Application No: AB/135/20/OUT
Site Address: Land at Ford Road Arundel
Description of works: Outline application with some matters reserved (except for access) for the development of 90 dwellings & associated amenity land, including land for a community building & for a community allotment. This application affects the setting of listed buildings & affects the character & appearance of the Arundel Conservation Area.

Thank you for your internet representation made on 16th March 2021 which has been recorded as an objection with the comments as follows:

This is an objection on behalf of Sustrans and the Bognor Regis Cycle Forum.

Plate 2.2: WSCC Proposed Cycle Routes (red lines)

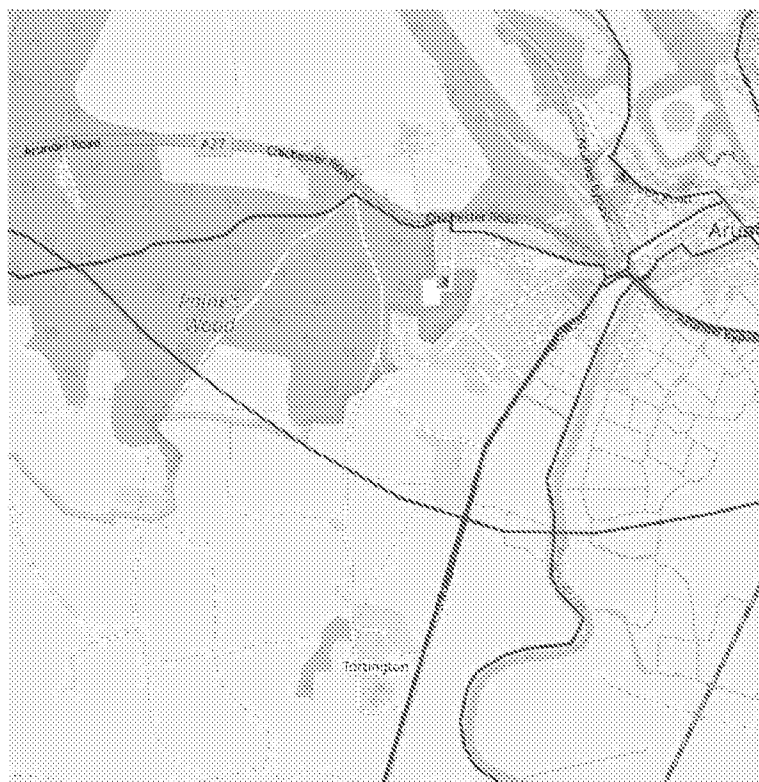
There should also be cycle links to the south onto Priory Lane. This would then enable residents to easily access Tortington Lane to the south (and so avoid a large stretch of Ford Road) and well as north into Binstead Woods.

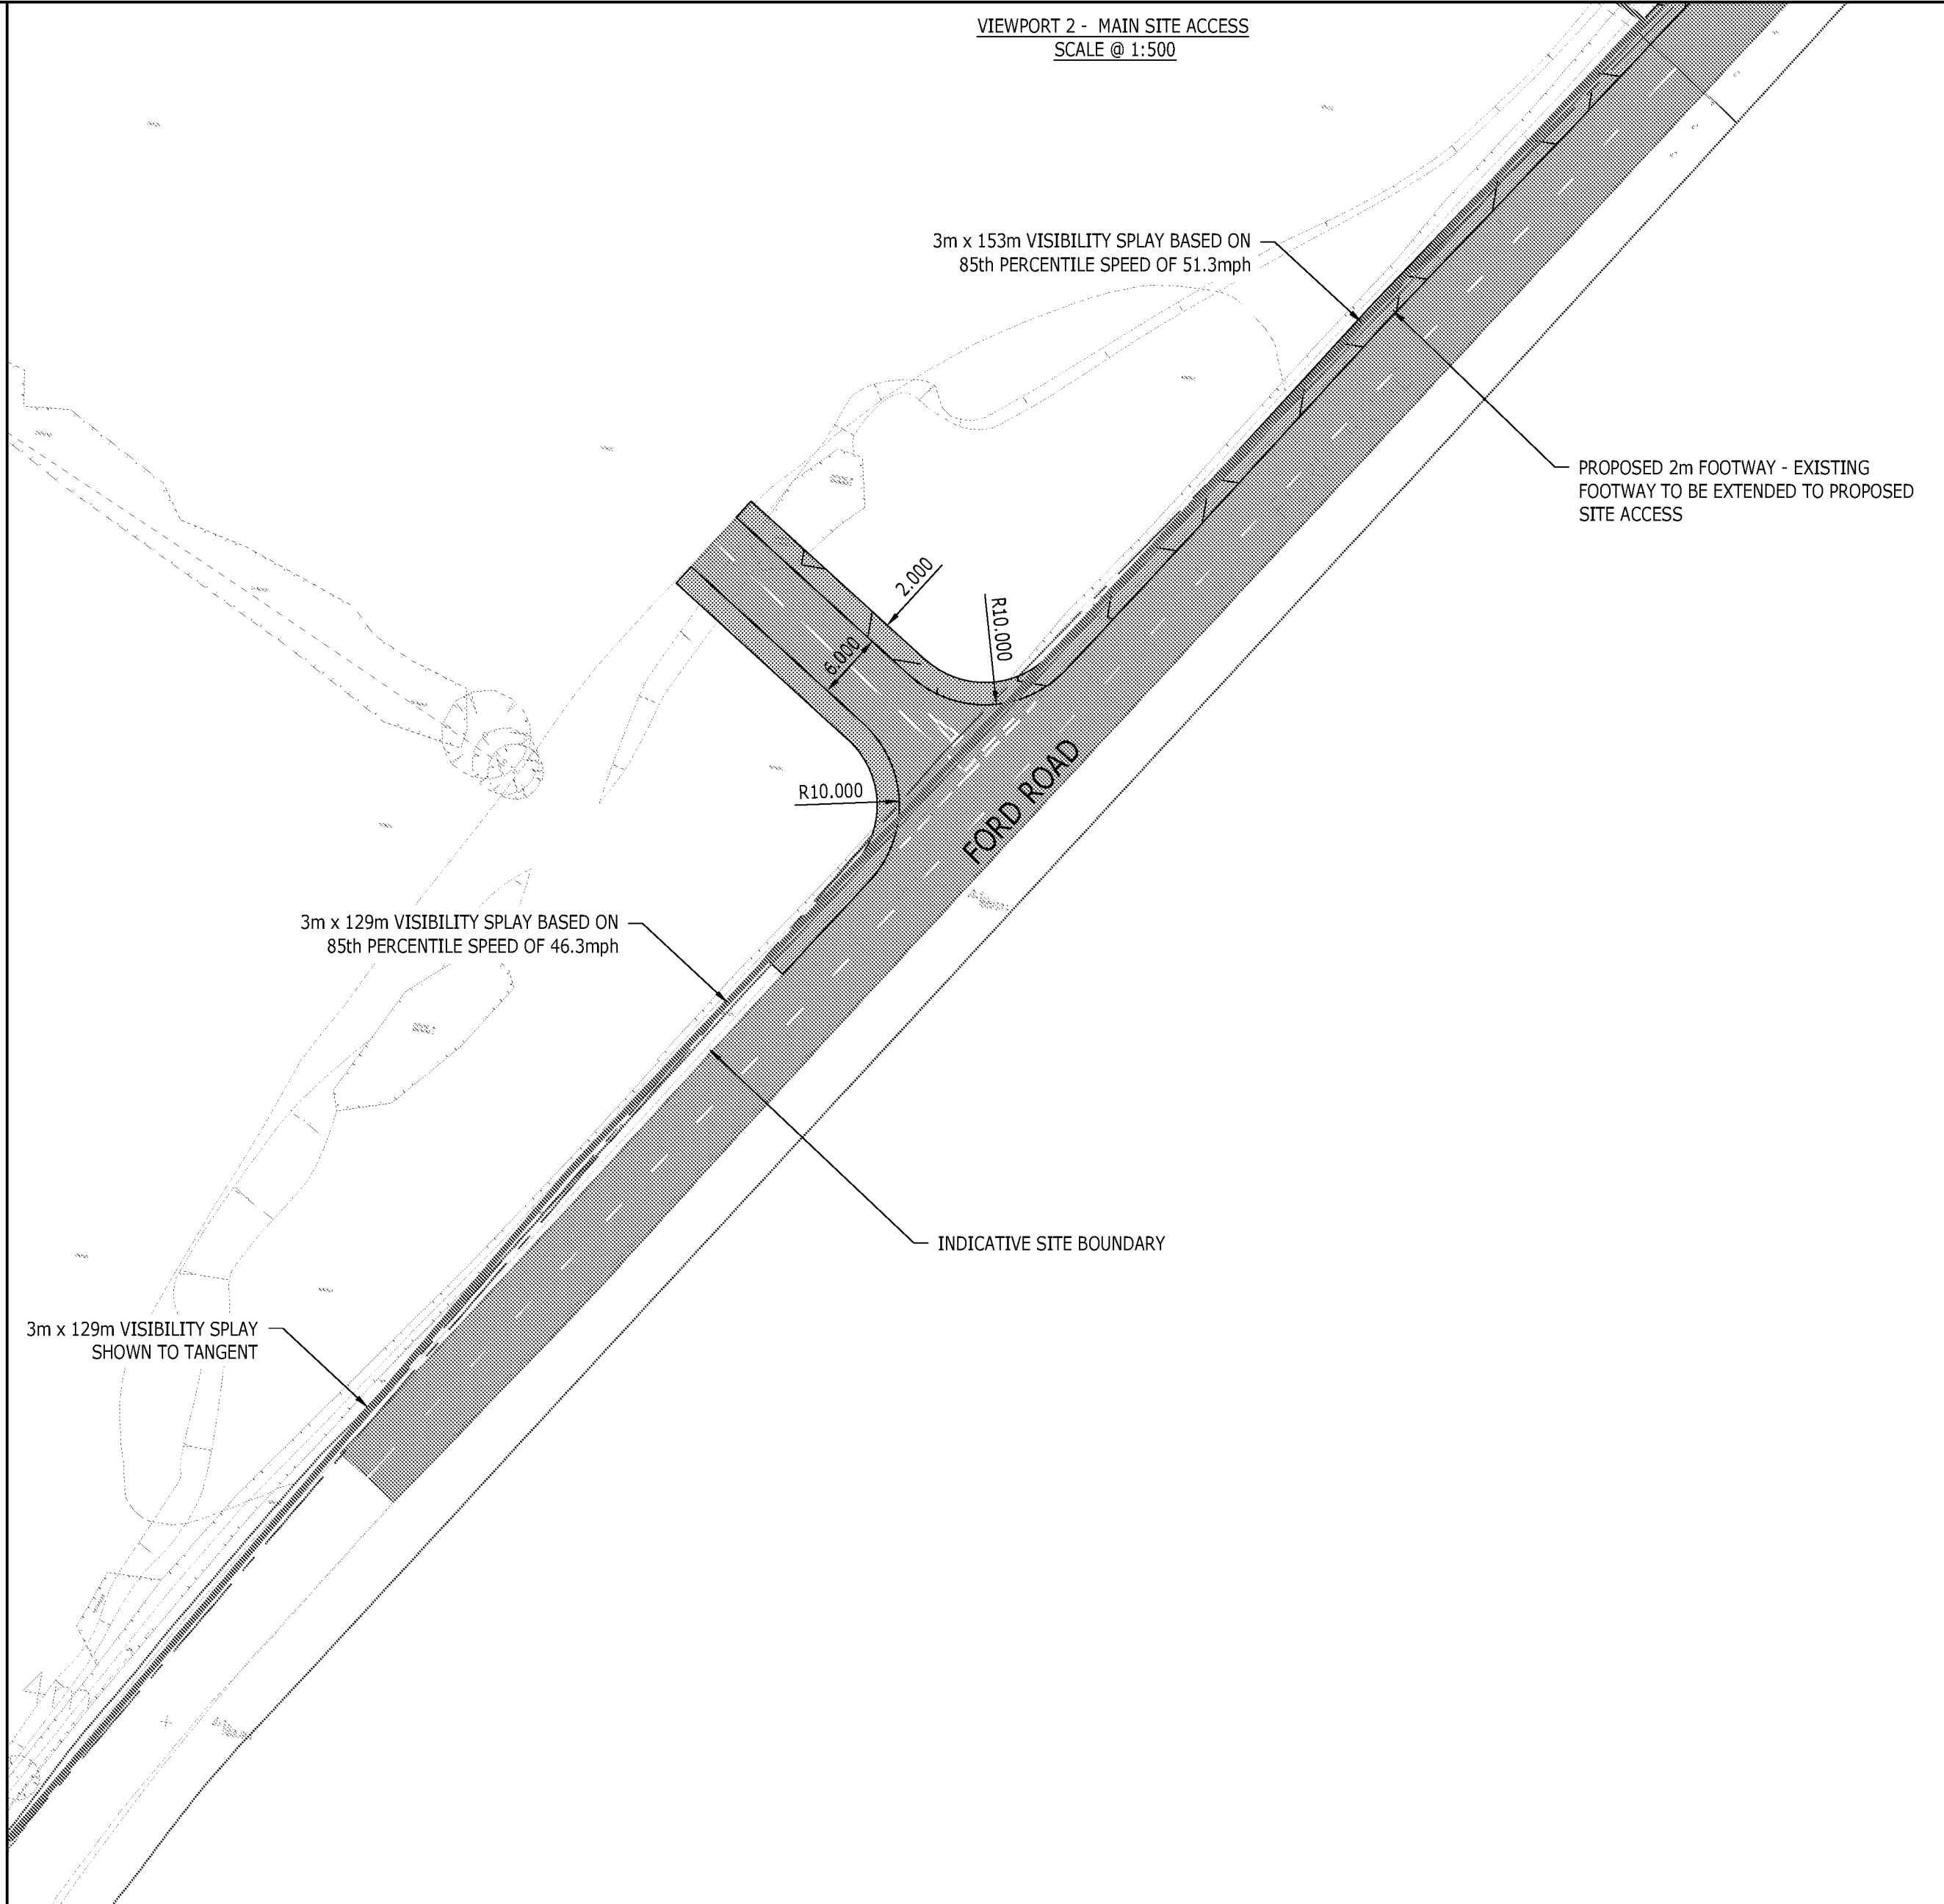
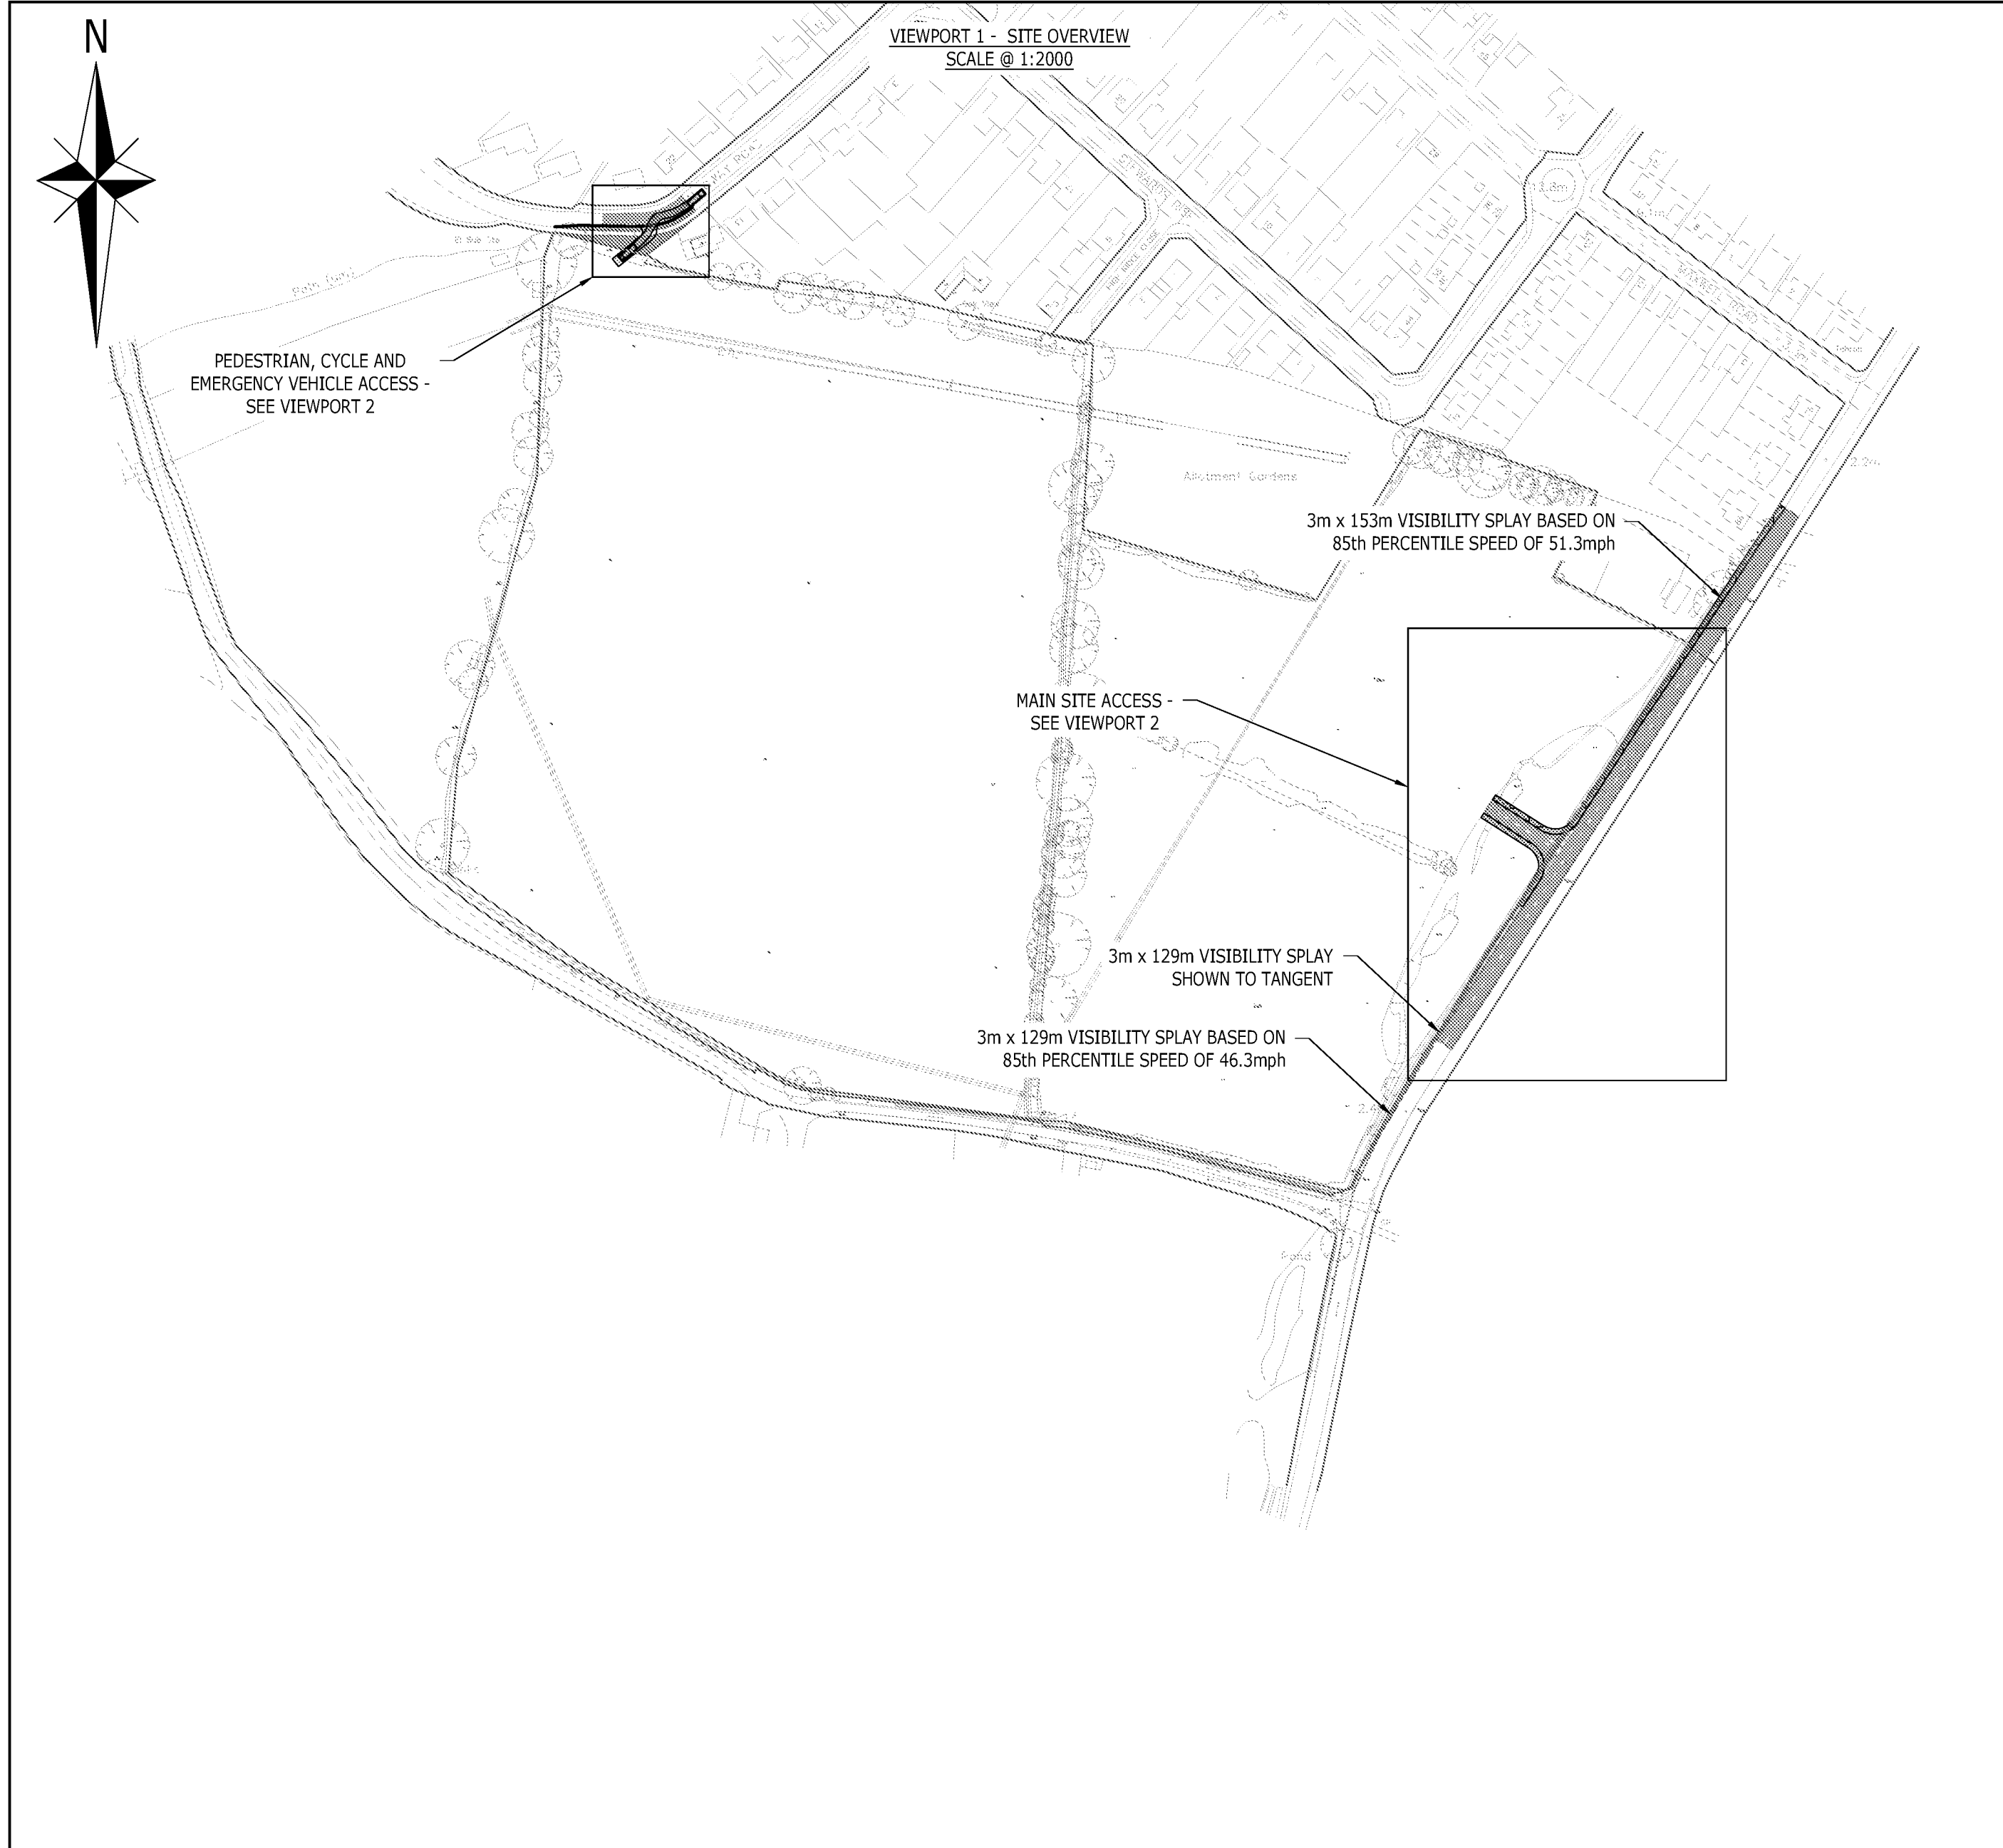
In respect of the main vehicular access to the site off Ford Road, it is very dangerous that there is no provision for traffic calming or speed reduction at that point. In addition, bearing in mind the long term aim of providing a safe segregated cycle connection between Arundel and Ford Station alongside Ford Road, there has been no reference to this, and if the development goes ahead, then S.106 monies should be required to go as a contribution towards the Arundel/Ford Station cycle link.
